Affordable Housing Consultation response for:

Former Lombard Service Station, Brook Road, Southville,
BS3 1AJ

Planning Ref: 21/00241/F

Description Redevelopment of former Lombard Service Station to provide 10 self-contained residential flats.

Title
Ground Floor Plan - Proposed

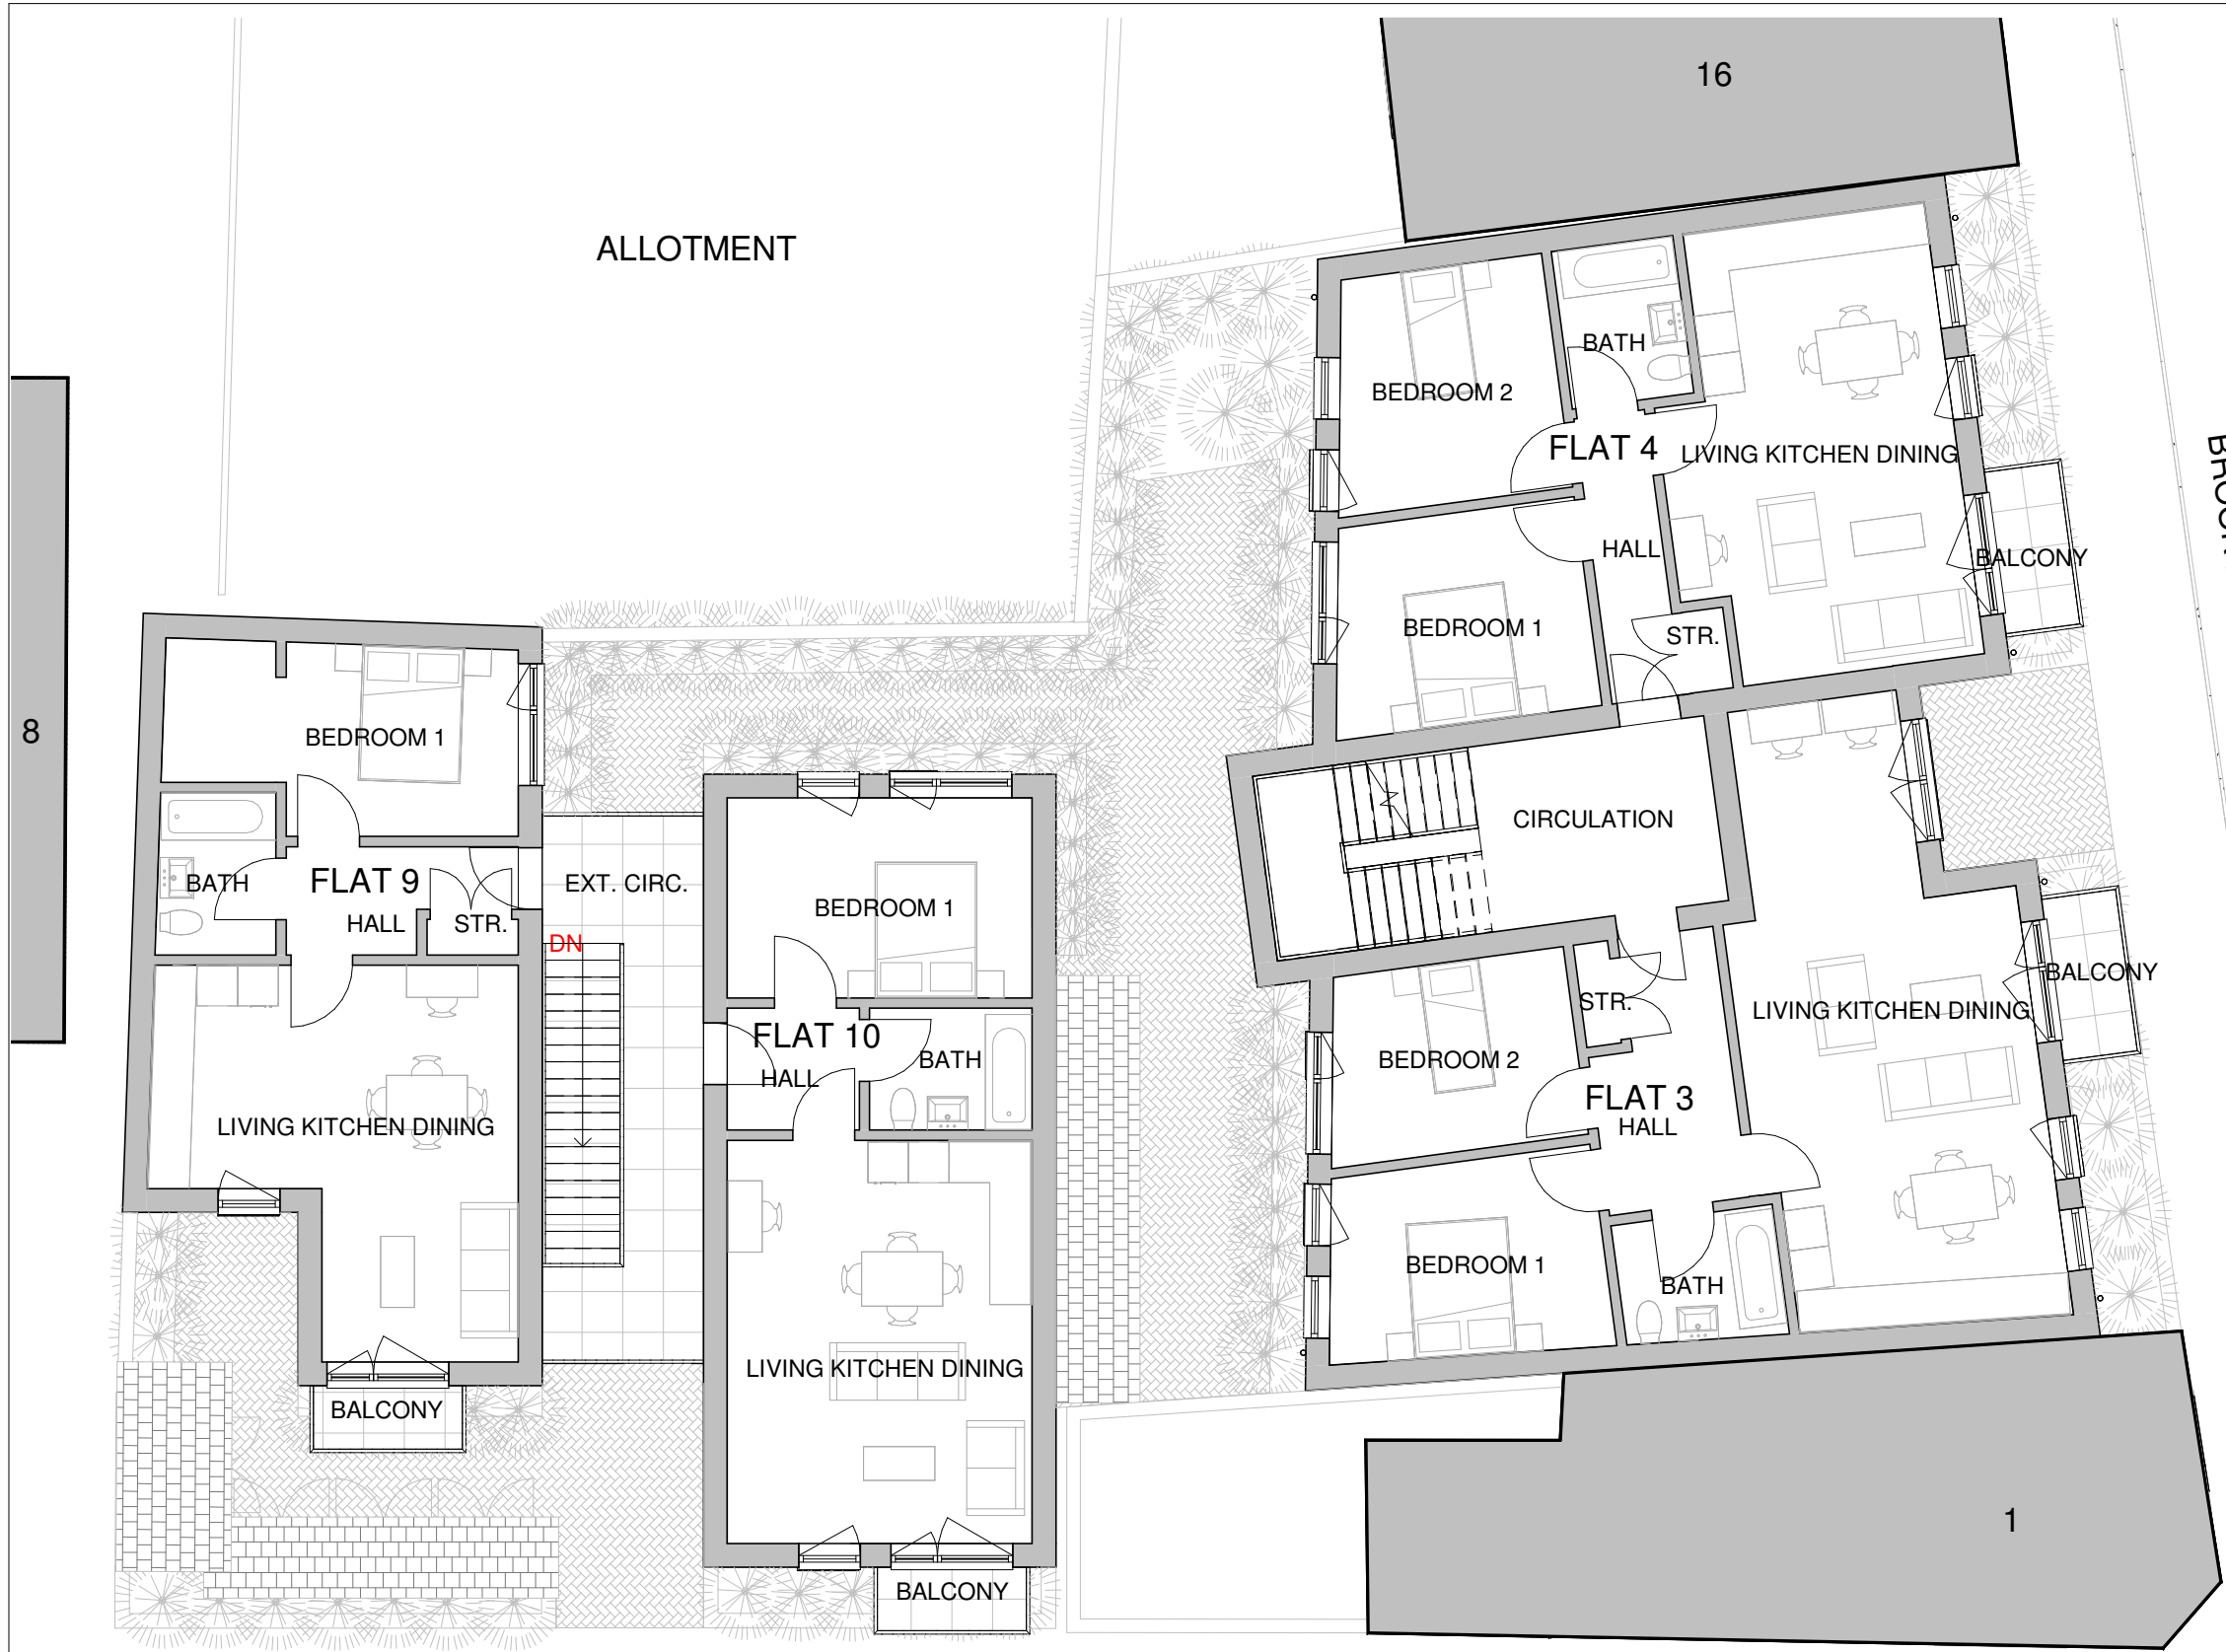
It is not accepted that the site is unsuitable for on site provision. The 20% requirement equates to 2 affordable units. Tenure mix should be 77% social rented units and 23% shared ownership. In this instance we would propose for management purposes that both units are of the same tenure and the default policy option is 2 social rented units as follows.

The layout of the units facing St Pauls Road lends itself to provision of a separate affordable block of two no. one bed units and it is proposed that the two storey block farthest to the North is the affordable block. Indicated by red line in the attached.

The scheme is in a sustainable location and is an opportunity to provide a successful mixed tenure scheme to meet affordable and market housing need/demand. The lack of private amenity space and the external stairway may be problematic for occupants unless it is well designed and well-lit and the dwelling entrances have adequate overhanging porches and external lighting. The lack of amenity space apart from the balconies is a concern and it will be important to design the balconies to be used effectively, rather than just for ornamental or occasional use. The applicant is reminded of policy DM 27 Form and Layout viii *“Enable the provision of adequate appropriate and usable private or communal amenity space, defensible space, parking and servicing where necessary”*.
